CITY OF ALBUQUERQUE

March 6th, 2018

Site: Glendesto

Re: Drainage Ordinance (14-5-2-1) Violations for Erosion and Sediment Control and Construction Site Waste(s)

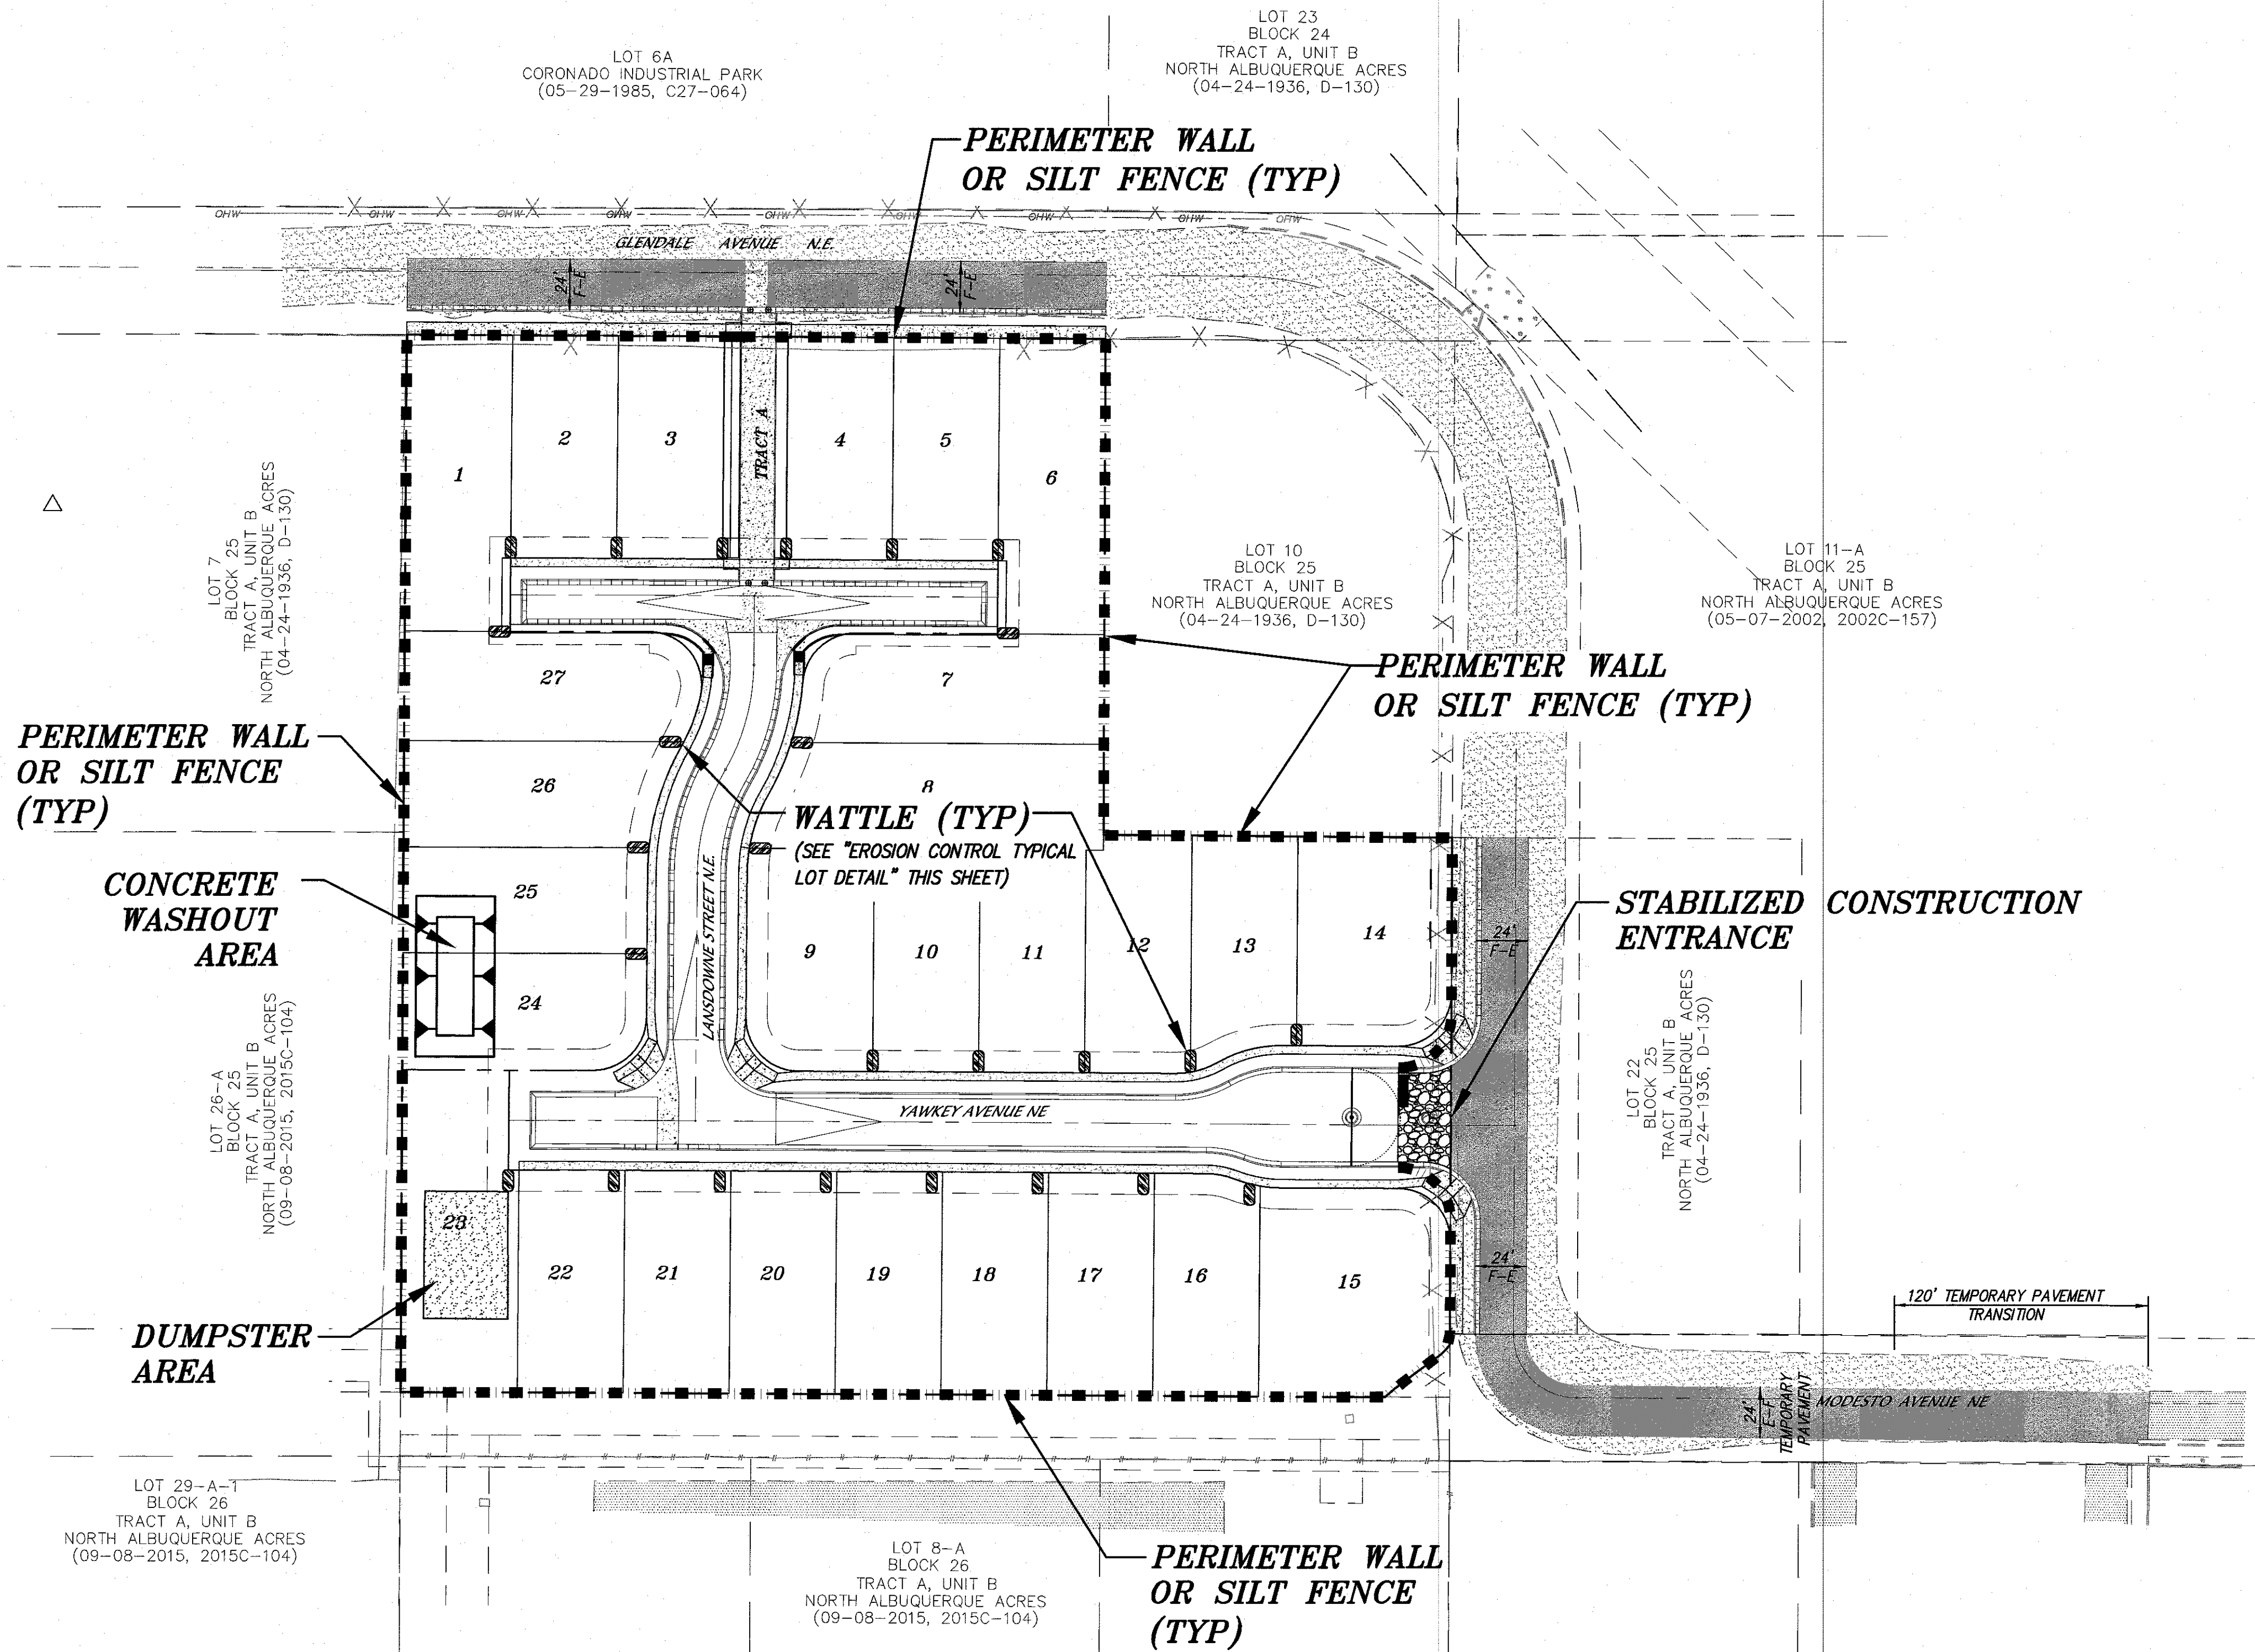
1. There were no sediment BMPs for the work shown on the Work Order construction plans: filter socks at Modesto and San Pedro, inlet protection and no sweeping.
2. San Pedro Blvd was covered in dirt.
3. No inlet protection at the side inlet to the channel.
4. Sediment in gutter pan on easement street.
5. Concrete wash-out in the street.
6. There was no acceptable wash-out facility on-site.
7. Dirt pile in easement street without BMPs.
8. There was earth disturbance outside the project limits on the west side and no sediment BMPs.

1. Provide sediment BMPs for the work shown on the Work Order construction plans. These include filter socks at Modesto and San Pedro, inlet protection and sweeping. See approved Erosion and Sediment Control Plan.

2. Remove sediment from San Pedro Blvd and Modesto Ave west of San Pedro.
3. Sediment is not to be observed in Modesto Ave west of San Pedro and on the south-bound lane of San Pedro.

4. Provide inlet protection at the side inlet to the channel.
5. Remove sediment in gutter pan on easement street uphill from the side inlet to the channel and keep the gutter pan free of sediment.

6. Remove concrete wash-out in the street.
7. Provide an acceptable wash-out facility on-site and have workers use it.
8. Provide a sediment BMP for the dirt pile in easement street or remove it. Do not stockpile dirt in the street without a sediment BMP.

9. Provide sediment BMP(s) for the disturbed area west of the project.
